Memorandum

Planning and Urban Development Department

Date: November 8, 2013

Re: Design Review 133 York Street
R6 Design Standards

1
A-202
NORTH ELEVATION
SCALE: 1/4"=1'-0"

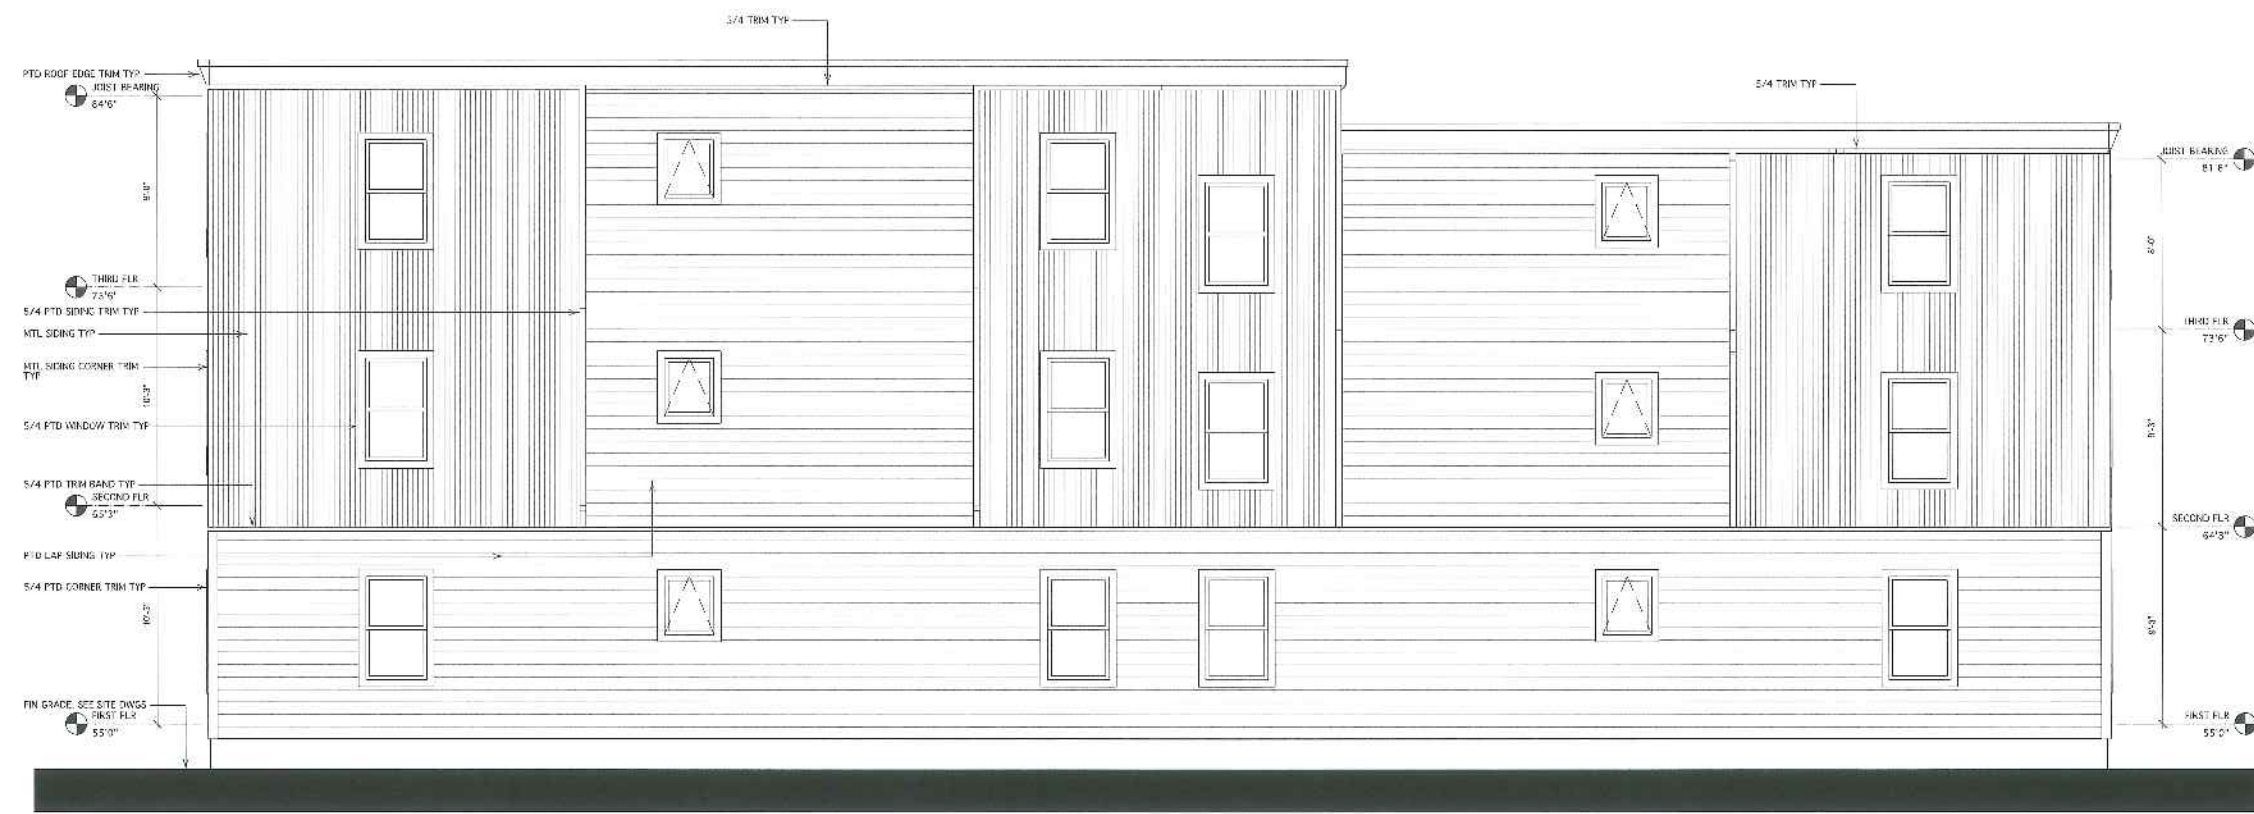
5. The proposed design should also address the Principle F re “Articulation” (extracted below) and the rear elevation remains weak in relation to this standard. Staff remain disappointed in the rear elevation treatment. It is more balanced with the addition of windows and benefits from the larger cornice treatment. However, it

still lacks in articulation and interest. The applicant has explored relatively minor cladding revisions and these do not fully address the Principle F regarding “Articulation”.
